April 20, 2023

Re: Grandview Reserve Geick Basin Channel - CDR

Colorado Parks and Wildlife (CPW) has reviewed the plans for the Grandview Reserve Geick Basin Channel in El Paso County, Colorado in the area of the future expansions of Rex Road between Eastonville Road and Highway 24. Colorado Parks and Wildlife (CPW) is in receipt of the above referenced permit application and is familiar with the site. CPW offers the following comments for your consideration.

CONSTRUCTION DOCUMENTS
DETAILS
SHEET DT1
42

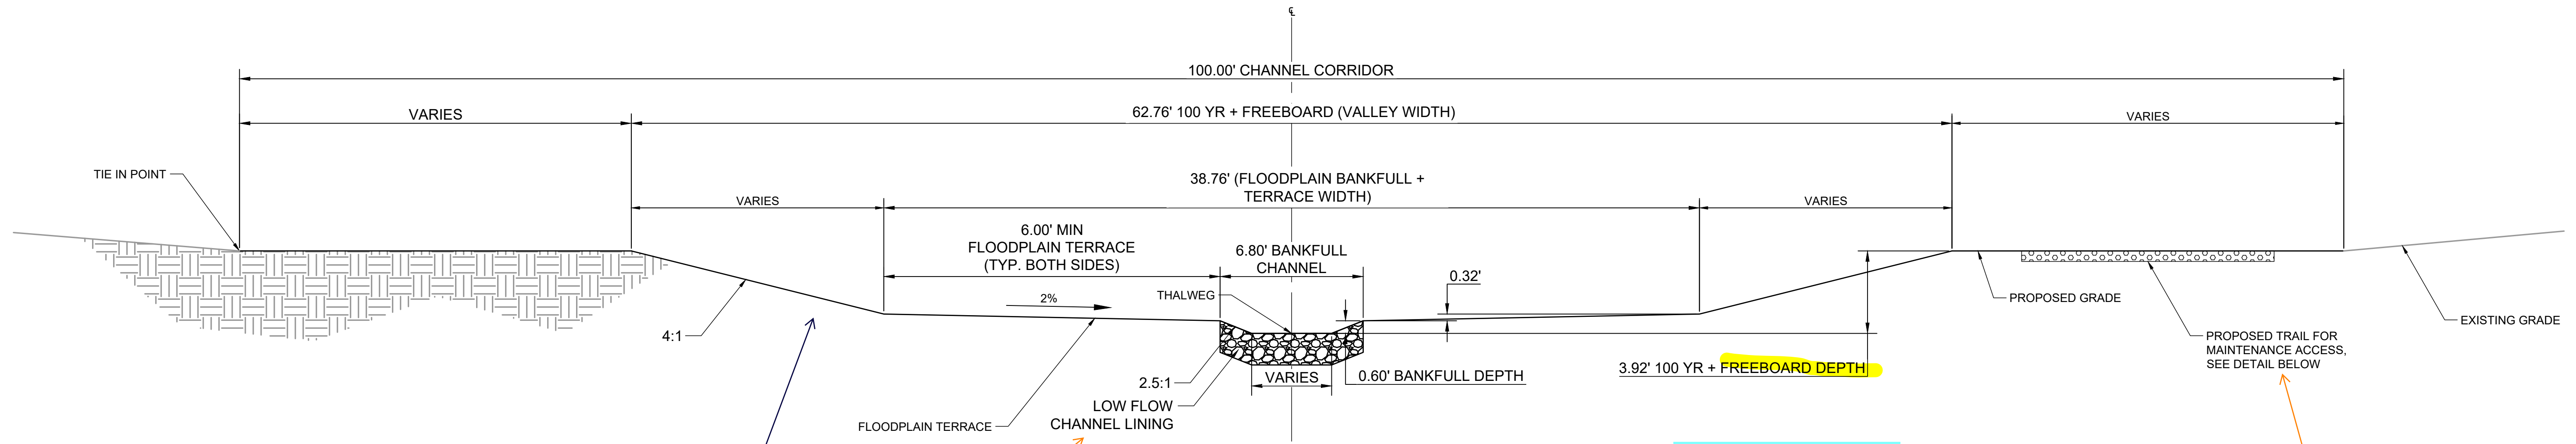
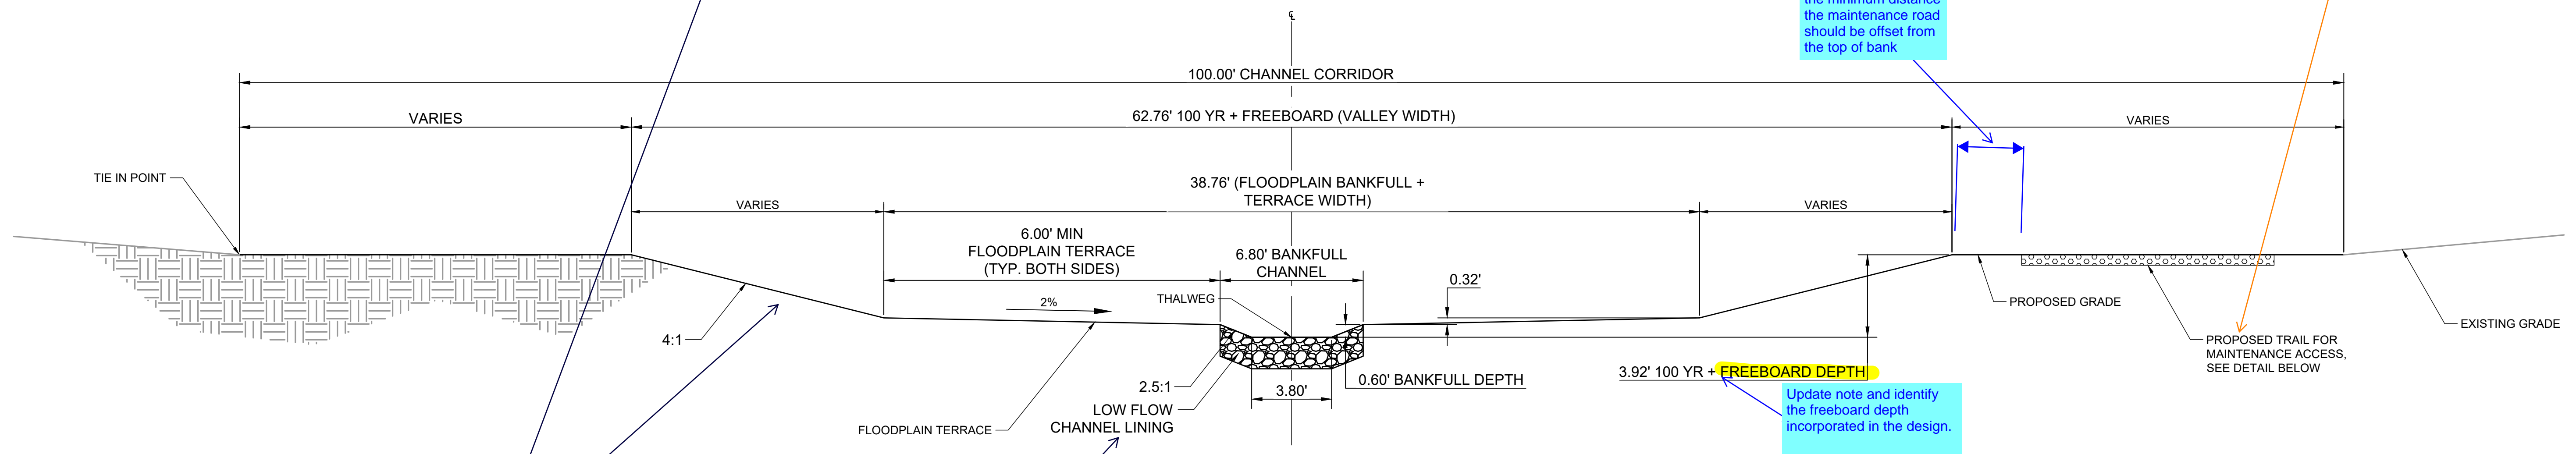
The design does appear to have a low flow channel is designed through most of the normal stream flow, but CPW feels that it is very important to reiterate that a low flow channel remain incorporated into the drop structure designs. Many native fishes and amphibians have difficulty navigating high velocity and sheet flows that many drop structures create. The design of the low flow channel should allow for upstream and downstream migration of fishes and amphibians that is essential for their reproduction, dispersion, distribution, and abundance. If designed properly, this channel should not compromise the integrity of the grade control structure and will be beneficial to wildlife inhabiting the stream.

CPW noted in the designs of the channel that most of the rip-rap throughout the drop structures of the project appear grouted. CPW recommends using non-grouted rip-rap throughout all portions of the plan. Vegetation and tree roots are more stable in non-grouted rip-rap and it can help provide habitat for small mammals. This not only benefits wildlife, but makes the construction more aesthetically pleasing.
